ASBUILT SURVEY
LOT 1, TRACT 1
FOUR HILLS VILLAGE
INSTALLMENT 11-A
CITY OF ALBUQUERQUE
BERNALILLO COUNTY, NEW MEXICO
AUGUST, 2014

DRAINAGE CERTIFICATION WITH SURVEY WORK BY PROFESSIONAL
SURVEYOR

GRADING PLAN

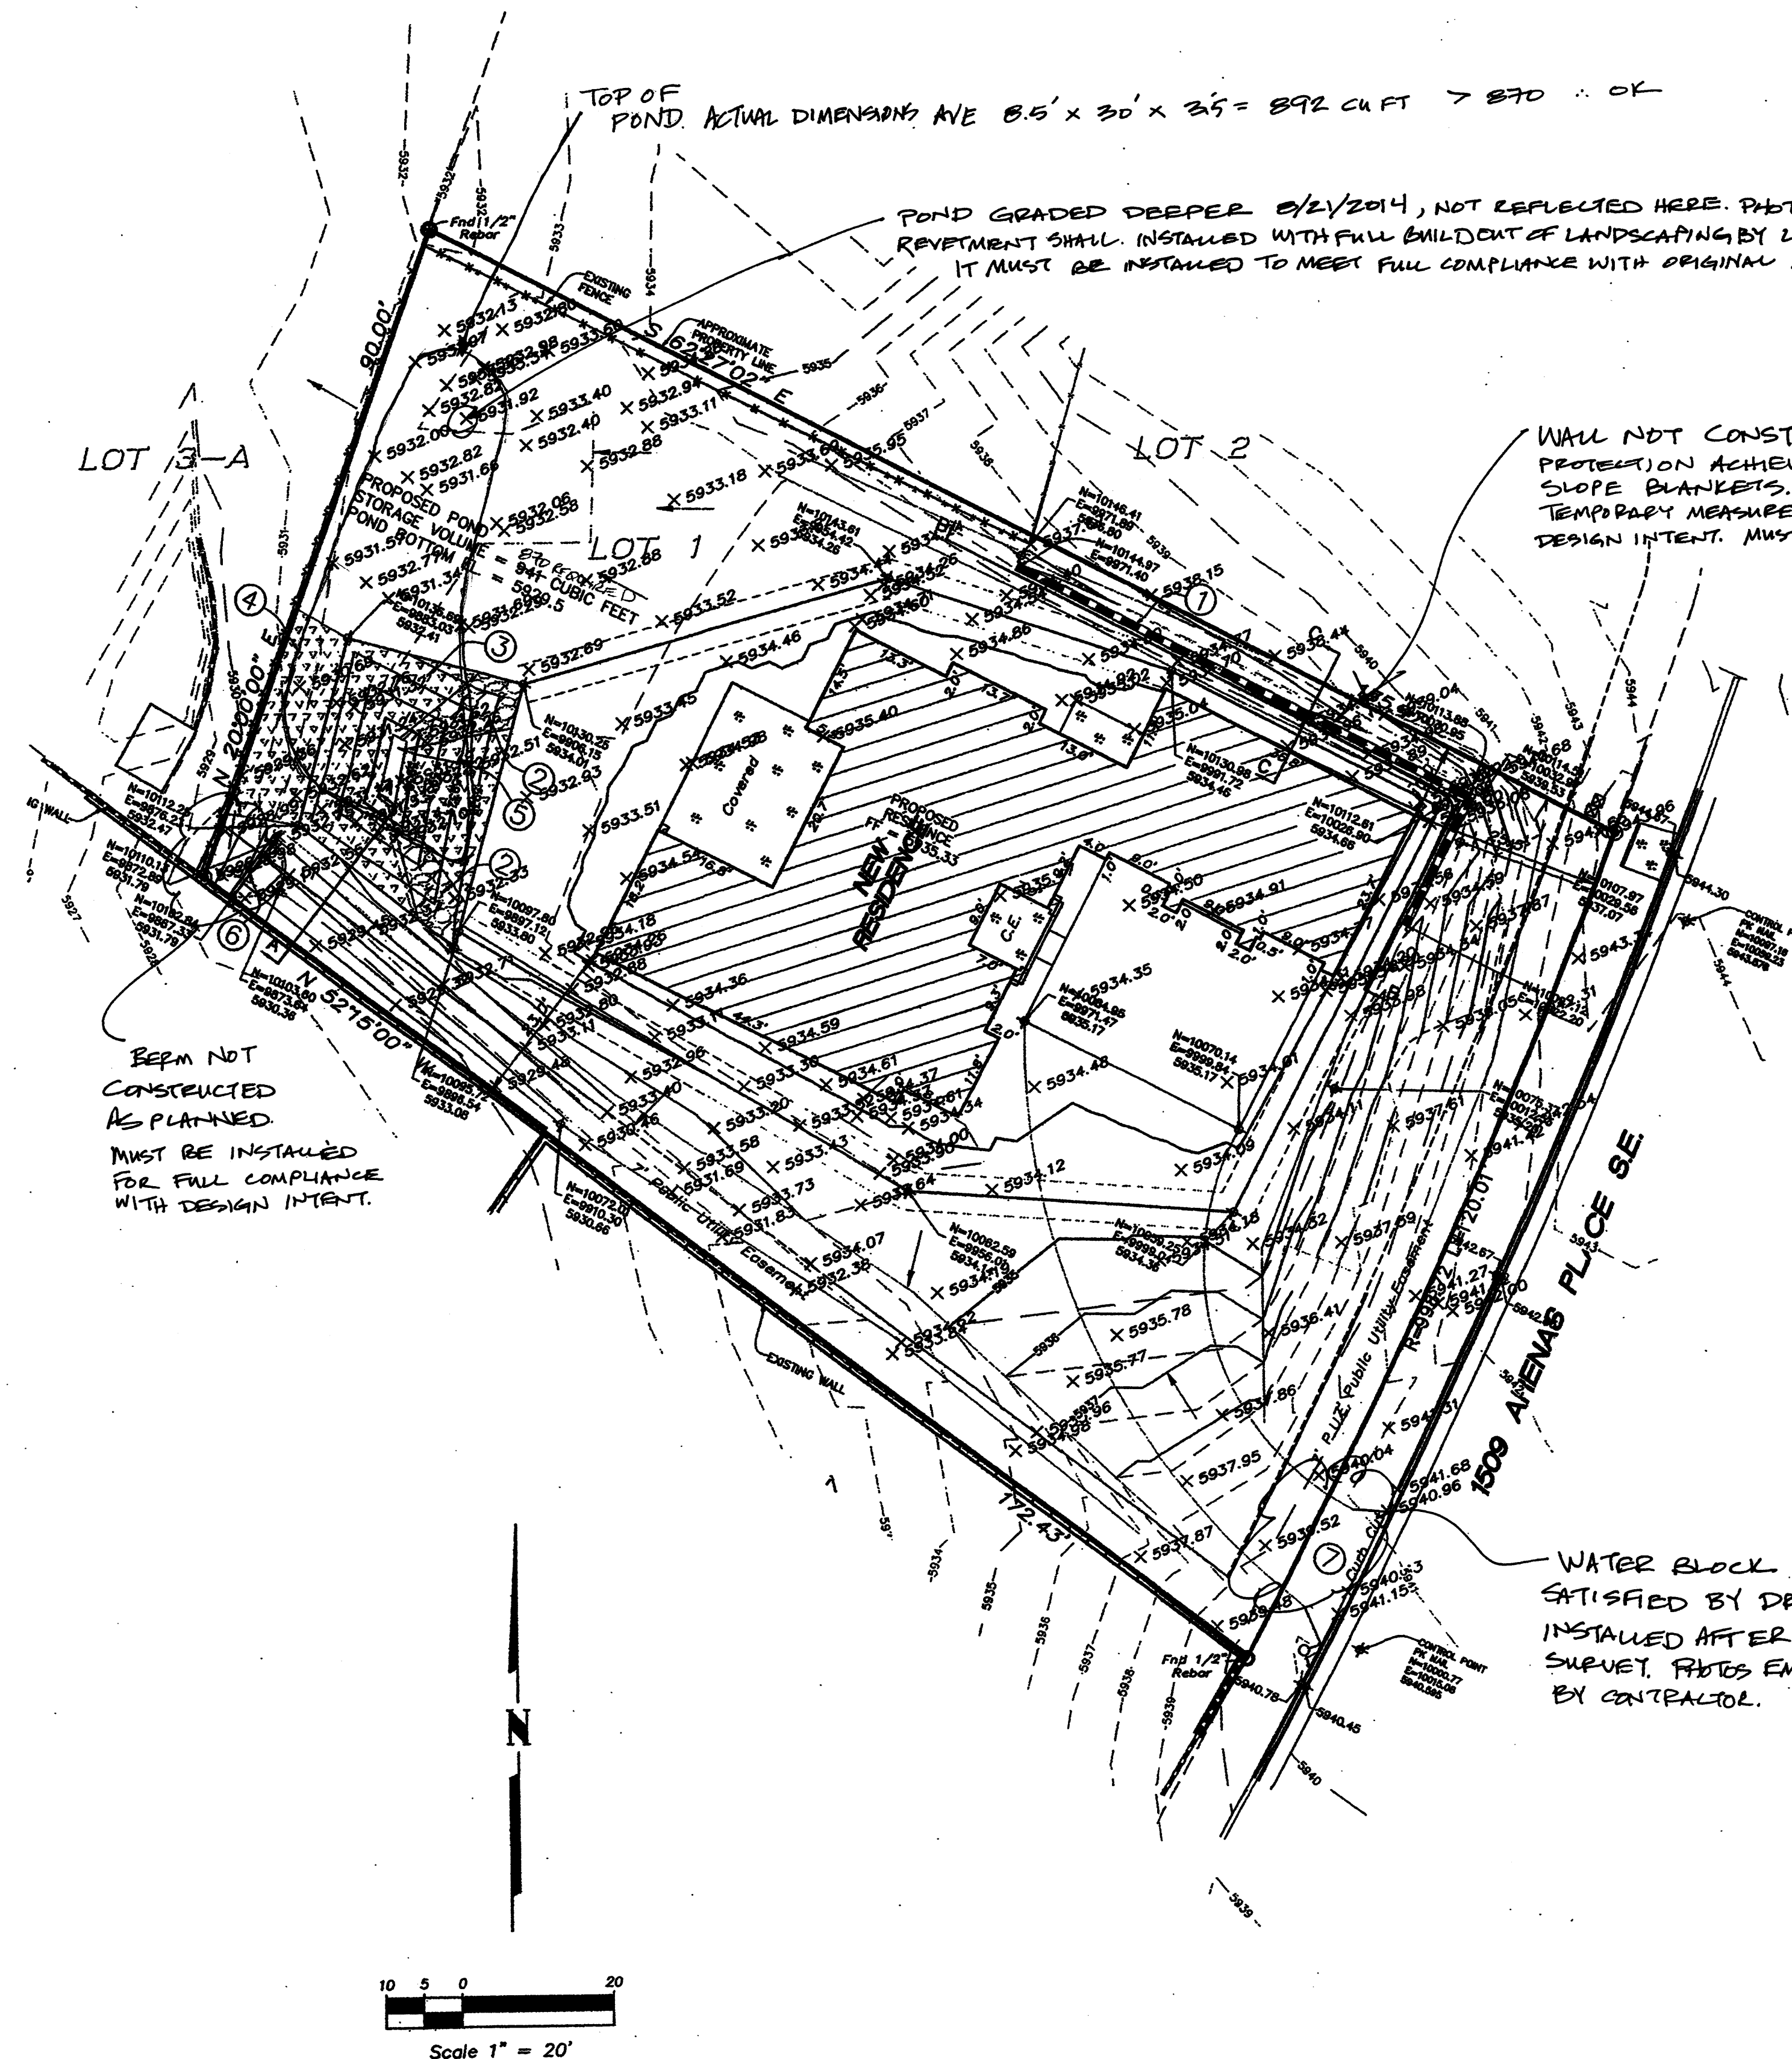
TOP OF POND ACTUAL DIMENSIONS ARE 65' X 30' X 2.5' = 872 CU FT > 870 CU FT

POND GRADED DEEPER 8/21/2014, NOT REFLECTED HERE. PHOTOS EMAILED TO CITY.
REVIEWMENT SHALL INSTALLED WITH FULL BUILDOUT OF LANDSCAPING BY LANDSCAPE CONTRACTOR.
IT MUST BE INSTALLED TO MEET FULL COMPLIANCE WITH ORIGINAL DESIGN INTENT.

WALL NOT CONSTRUCTED. EROSION
PROTECTION ACHIEVED USING
SLOPE BLANKETS. THIS IS A
TEMPORARY MEASURE THAT ACHIEVES
DESIGN INTENT. MUST BE MAINTAINED.

BEAM NOT
CONSTRUCTED
AS PLANNED
MUST BE INSTALLED
FOR FULL COMPLIANCE
WITH DESIGN INTENT.

WATER BLOCK
INSTALLED BY DRIVE PAD
AFTER THIS
SURVEY. RATES EMAILED
BY CONTRACTOR.
